Application No: LU/117/20/HH
Site Address: 68 Armada Way Littlehampton BN17 6QY
Description of works: Two storey side and rear extension, and alterations to existing garage to form habitable accommodation.

Thank you for your internet representation made on 8th June 2020 which has been recorded as an objection with the comments as follows:

PROPOSED SIDE
(NORTH) ELEVATION

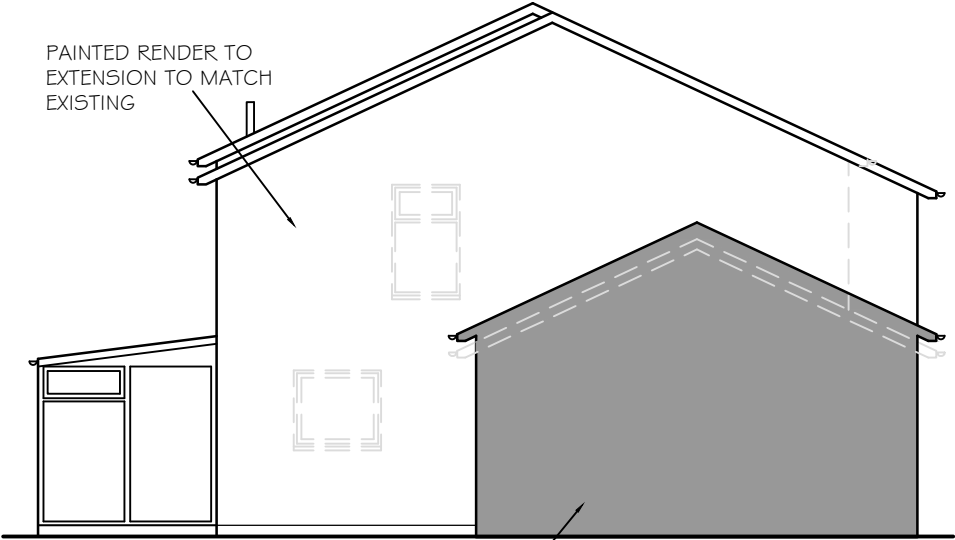
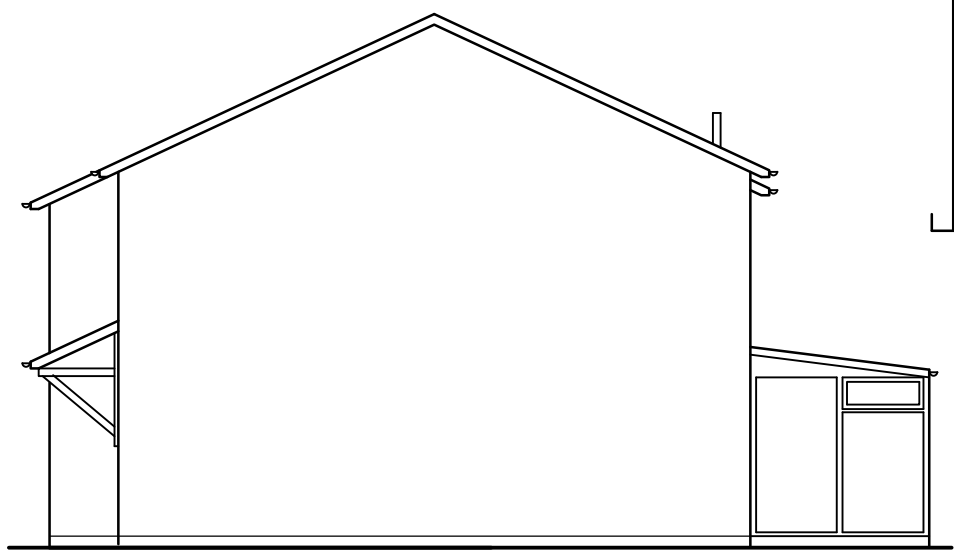
The side wall of the extension will totally engulf my patio. Making it very dark.

I have been made aware that the party wall will be build on my land. I object to this.

PROPOSED GROUND
FLOOR PLAN

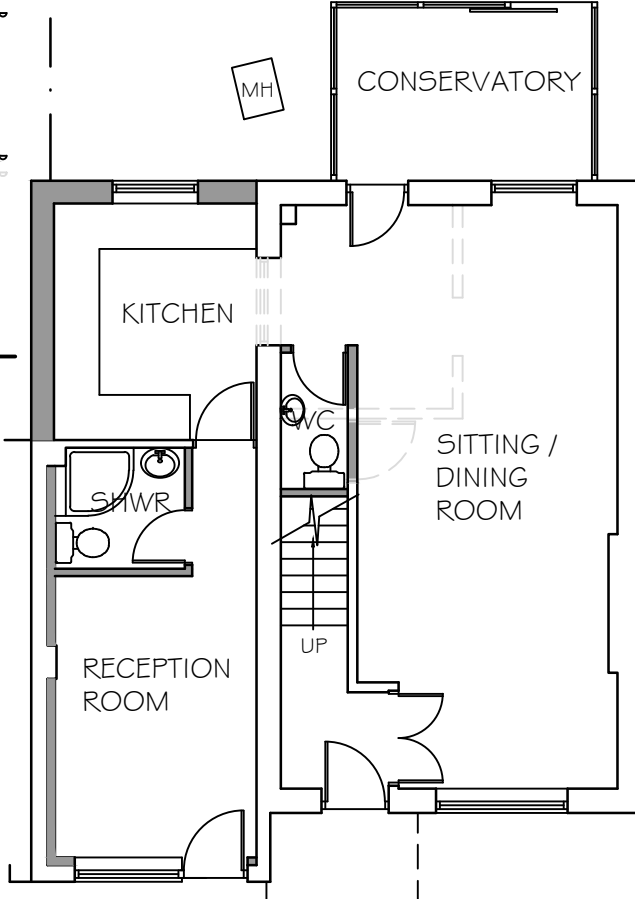
Looking at the plans. There are to be 4 toilets and 3 shower rooms! Why do they need so many if it is not eventually going to become a second dwelling?

PROPOSED FIRST
FLOOR PLAN

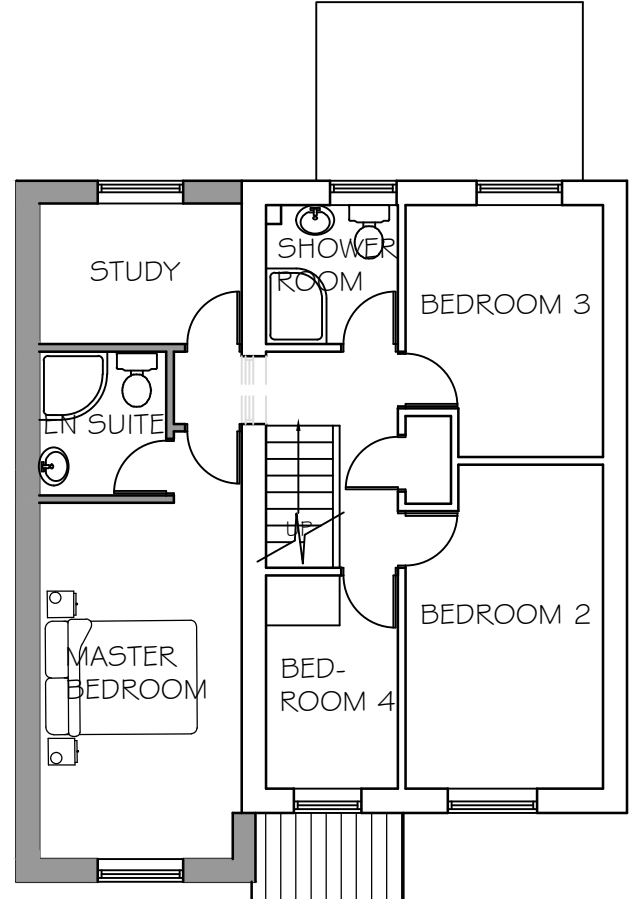
I have had correspondence from Mr and Mrs Donchevas' Surveyors. A detailed plan of what is being proposed was enclosed. I have already mentioned that the size of the extension will block out the afternoon sunshine from my garden. There is to be a window on the first floor which will over look my garden. Giving me no privacy when I am in my garden.
